Director Infrastructure Projects  
 Department of Planning and Environment  
 Major Projects Assessment  
 GPO Box 39  
 SYDNEY NSW 2001

**PROPOSED NORTHCONNEX M1 / M2 TUNNEL PROJECT - Application Number - SSI 13\_6136**  
**We object to many aspects of this project**

MOTORWAY OPERATIONS COMPLEX - SOUTHERN VENTILATION FACILITY - SECTIONS
M1-M2-5000-DR-JD-0525

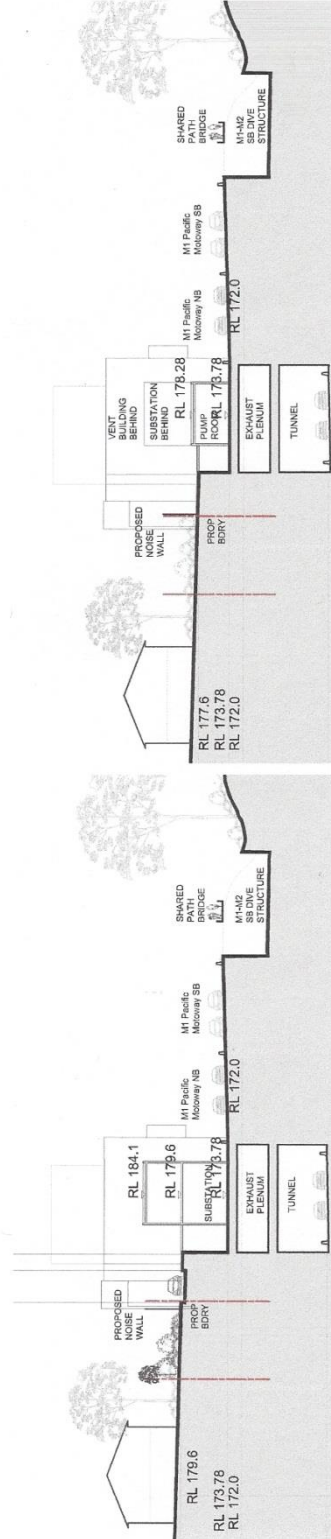
1. The Environmental Impact Statement (EIS) does not show any connection between the ventilation stack and the southbound tunnel which is 250 metres away. Will the polluted air be allowed to flow like an invisible sewer through West Pennant Hills, North Rocks, Carlingford and Beecroft?

**ACTION:** Provision of diagrams and detailed description of what ventilation is proposed for the southbound tunnel at the Southern Interchange. We would like the opportunity to lodge further submissions once that has been provided.
